From: Julie Grieves on behalf of Planning.Responses
Sent: 25 July 2019 09:48
To: Planning Scanning
Subject: FW: Planning Consultation on: BE/69/19/OUT

Comments from Greenspace

Site Address: The Cottage Shripney Road Bognor Regis PO22 9PA

Works: access for 31 No. houses and flats with car parking, landscaping and associated infrastructure & access off Shripney Road (A29), all following the demolition of the existing dwelling & outbuildings - This application is a Departure from the Development Plan

Existing Tree diagram

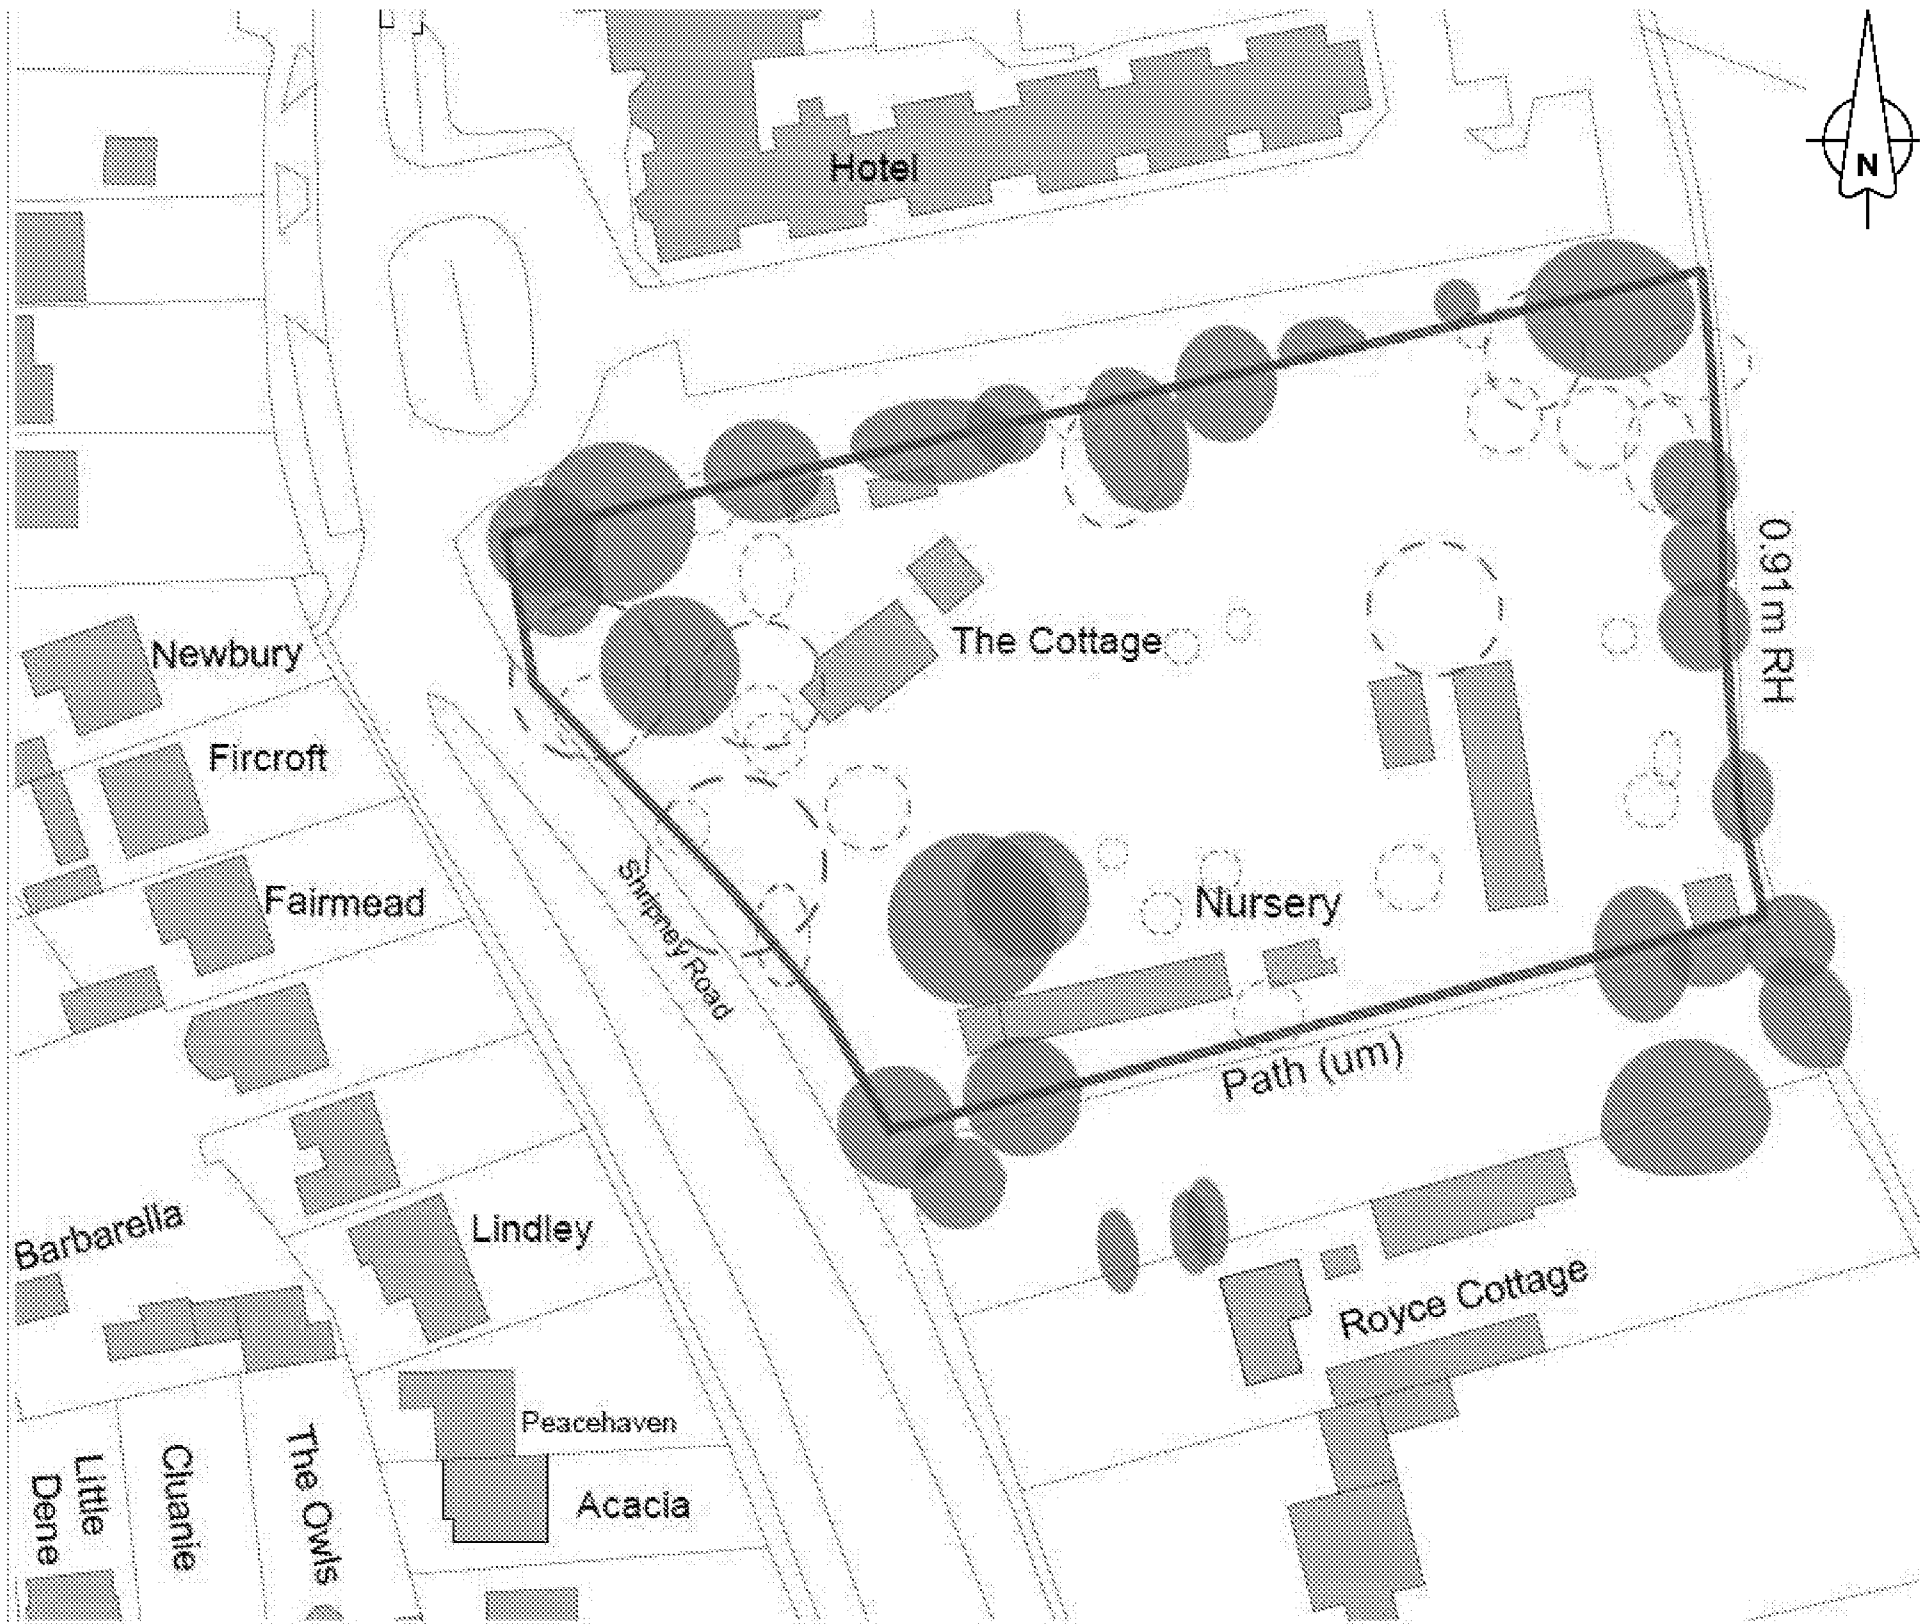
A full tree survey relating to existing trees would need to be undertaken. It would appear that several trees are proposed to be removed for these proposals. Tree protection fencing requirements for all trees to be retained would need to be identified and tree protection plans submitted which would need to be conditioned with any permission.

Before construction, the tree protection scheme must be in place for any retained trees including trees whose root protection areas fall within the construction zone from neighbouring land. Any agreed removed trees should be mitigated for allowing for inclusion of native species for biodiversity purposes and fitting to this semi-rural setting.
